## 470 Riverside St

**Adam Wallace** <adam@kaplanthompson.com>  
To: Glenn Harmon <gharmon@portlandmaine.gov>  
Cc: John Ready <john@readyseafood.com>

Fri, Feb 23, 2018 at 11:33 AM

LIFE/SAFETY PLAN  
A-1.0

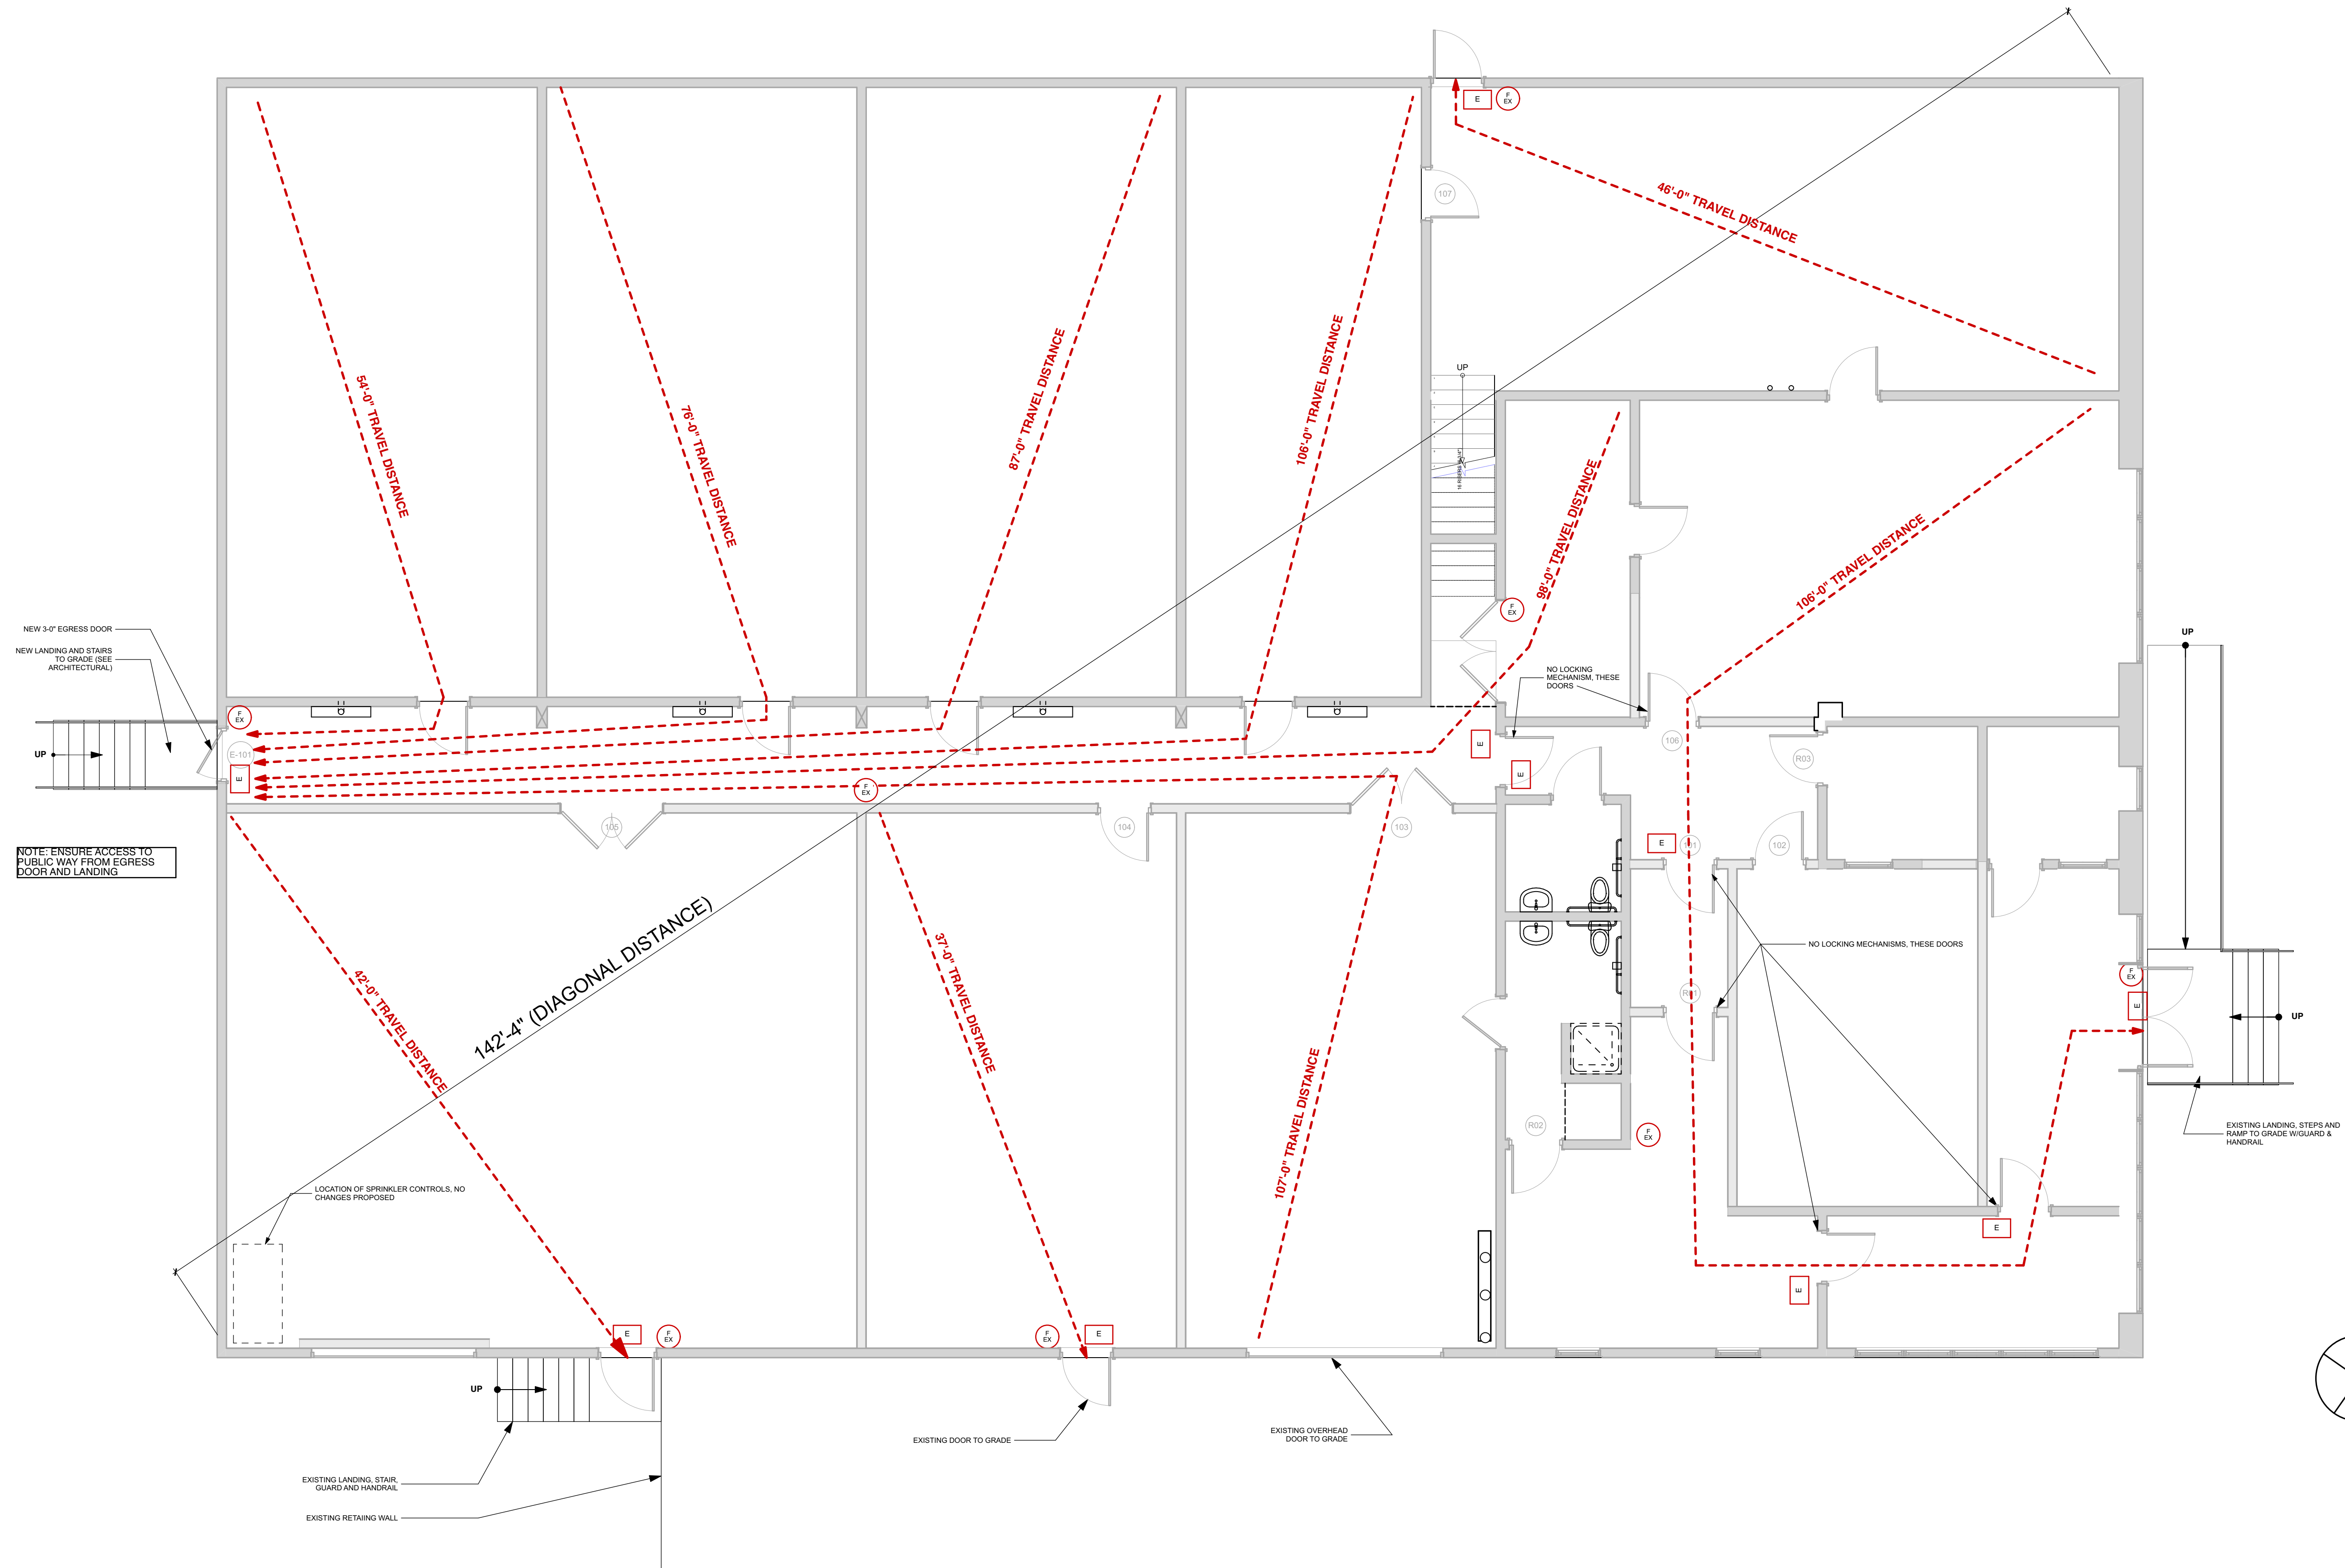
- *Does this discharge to a public way per 1027.6? Unclear on site plan.*
  - Yes. Currently the exterior space is surrounded by a chainlink fence, to the back and side, the street side will be open to the public way.
- *What is area of storage mezzanine?*
  - The square footage is ~ 93 SF.
- *How is this condition resolved? Top all plans.*
  - The line of the wall above is not showing for some reason. The circled locations directly adjacent to the entry door are indicating the extension jamb of the door that aligns with the thick wall above. The glazing in that location sits just above the floor level. The end of wall condition is to be left unchanged. The wall stops short of the glazing.
